KITTITAS COUNTY FIRE MARSHAL'S OFFICE

September 20, 2011

Re: Kohl (BL-11-00016)

BOUNDARY LINE ADJUSTMENT		
PREPARED FOR PETER KOHL		
A PORTION OF THE SW 1/4 OF THE NE 1/4 OF SECTION 4, TOWNSHIP 19 NORTH, RANGE 15 EAST, W.M.		
KITTITAS COUNTY	DATE	JOB NO.
DWN BY G. WEISER	08/2011	046902
CHKD BY	SCALE	SHEET
D. PIERCE	1"=100'	1 OF 1

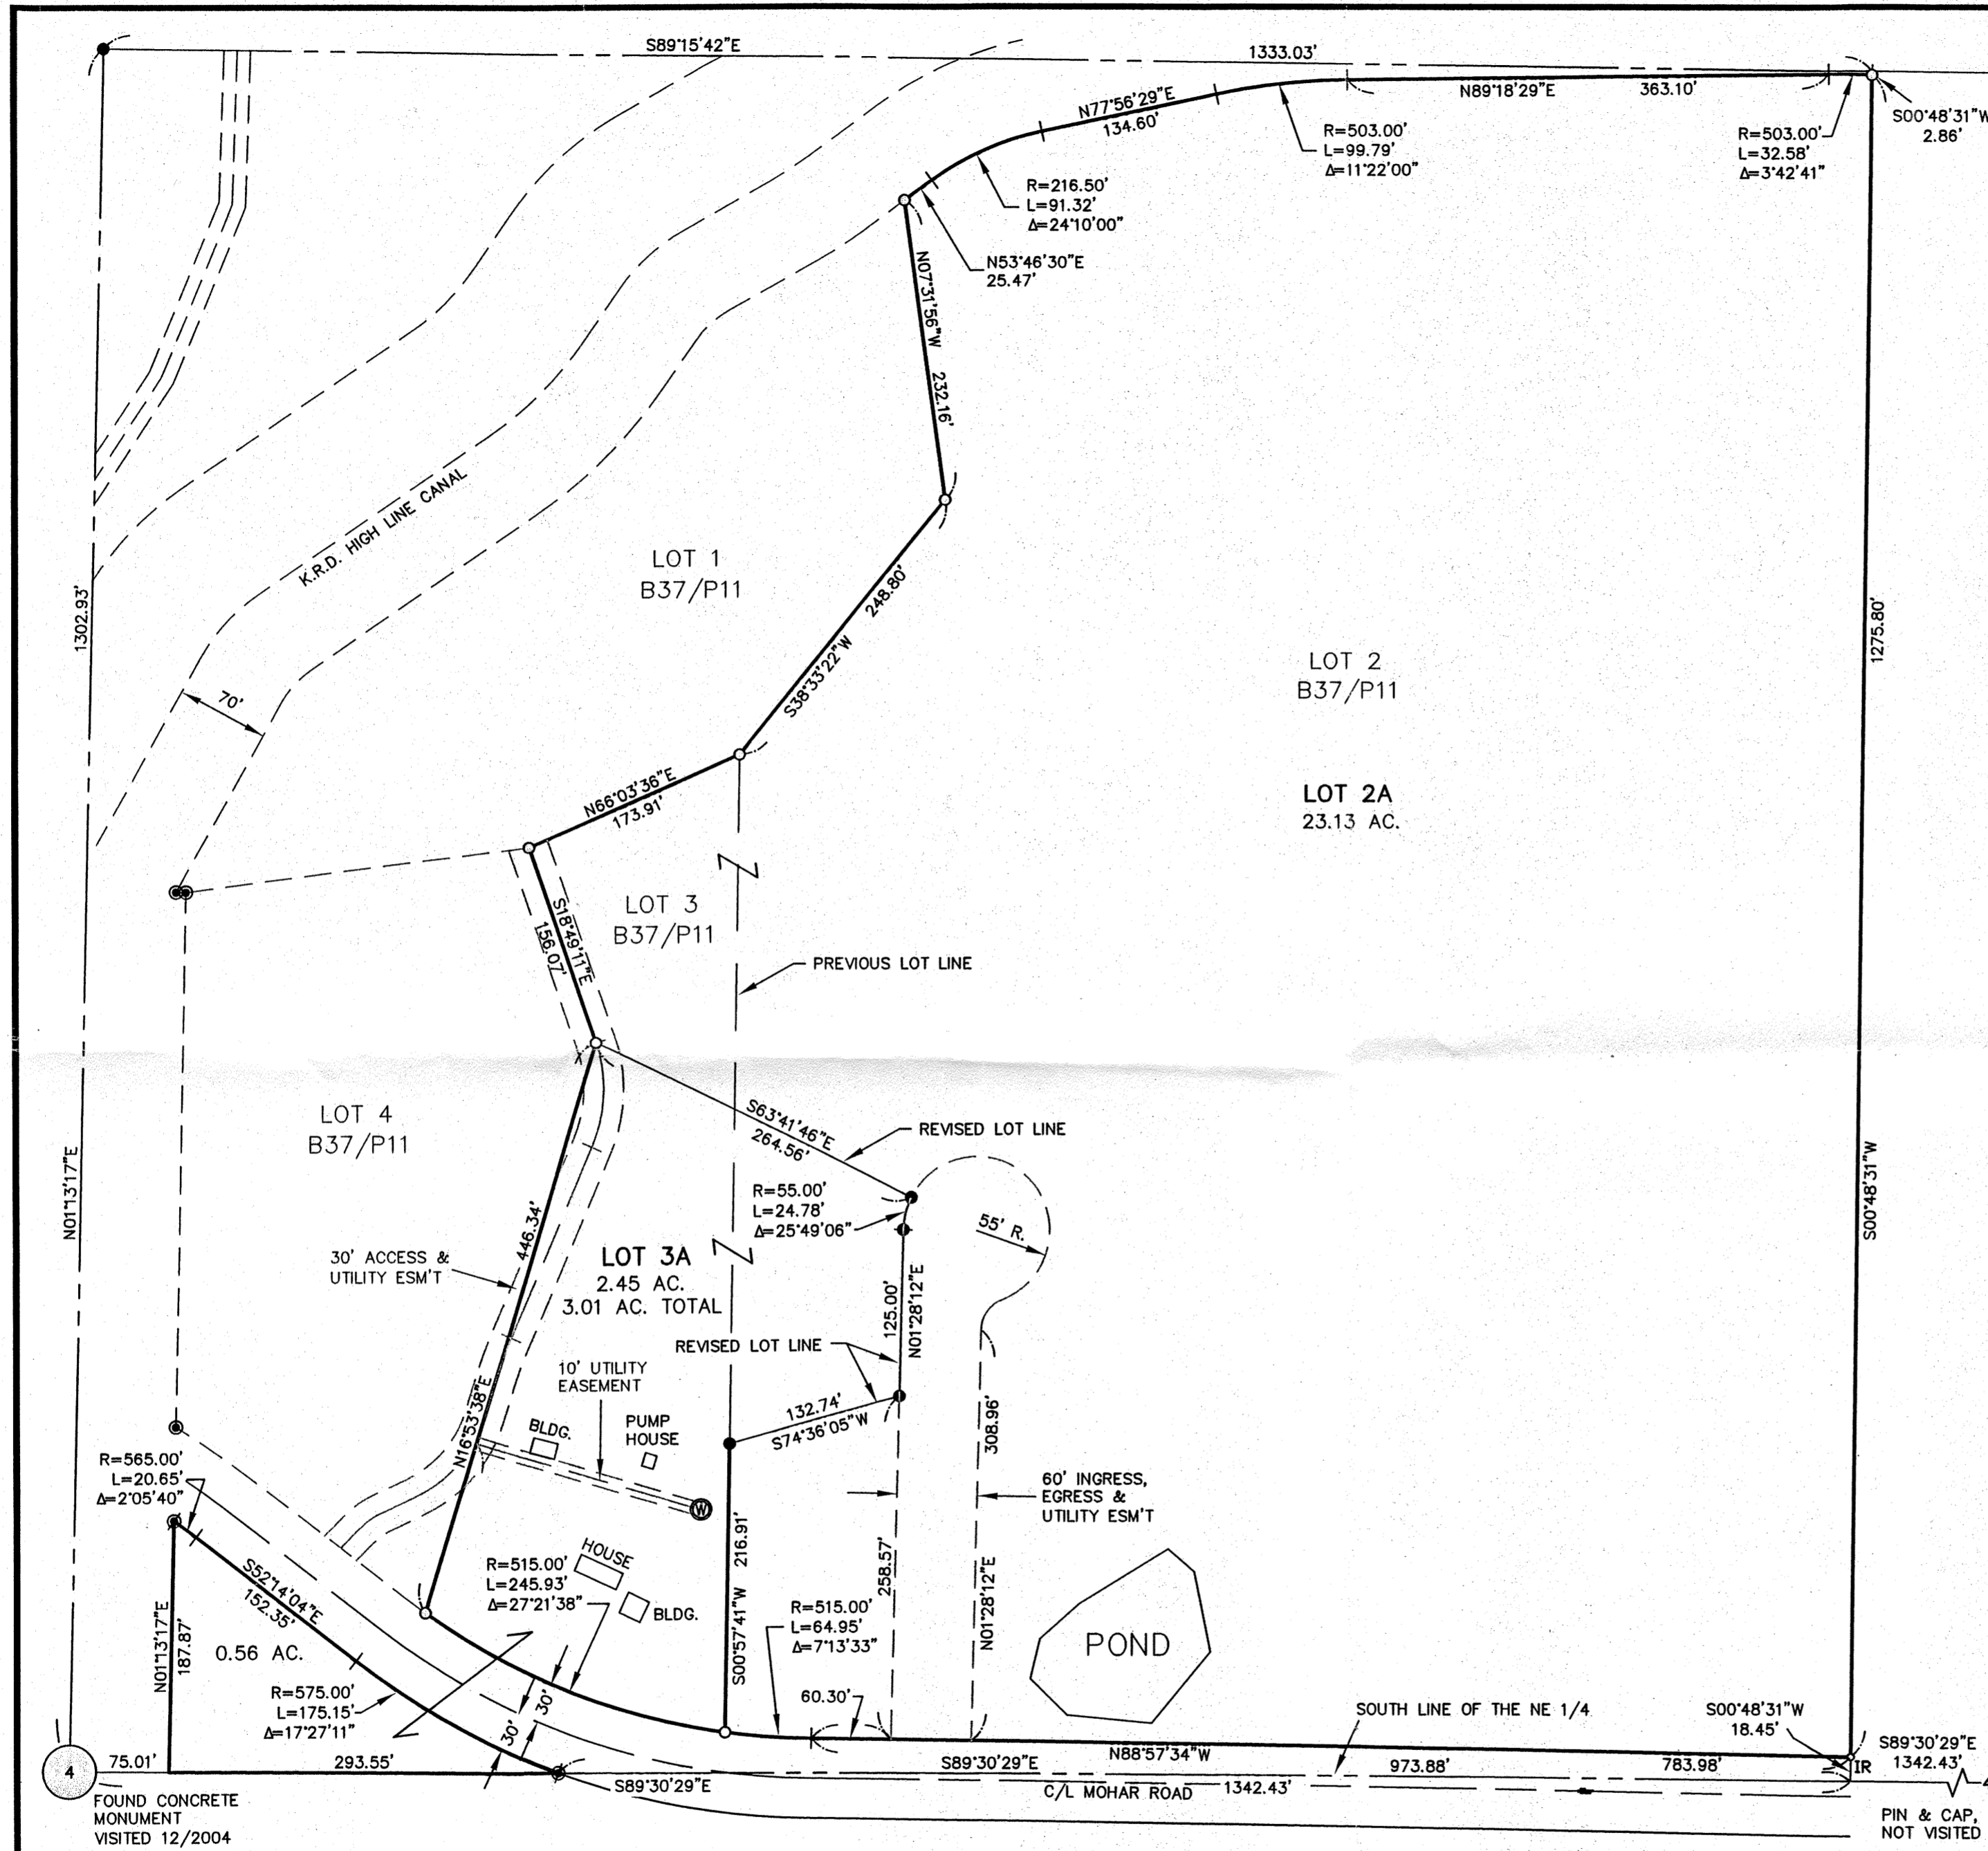
- Ensure that boundary line adjustments do not infringe upon existing structures, to include propane tanks, etc.
- Creation of any additional roads or access must comply with the International Fire Code.
- All future development must comply with the International Fire Code.
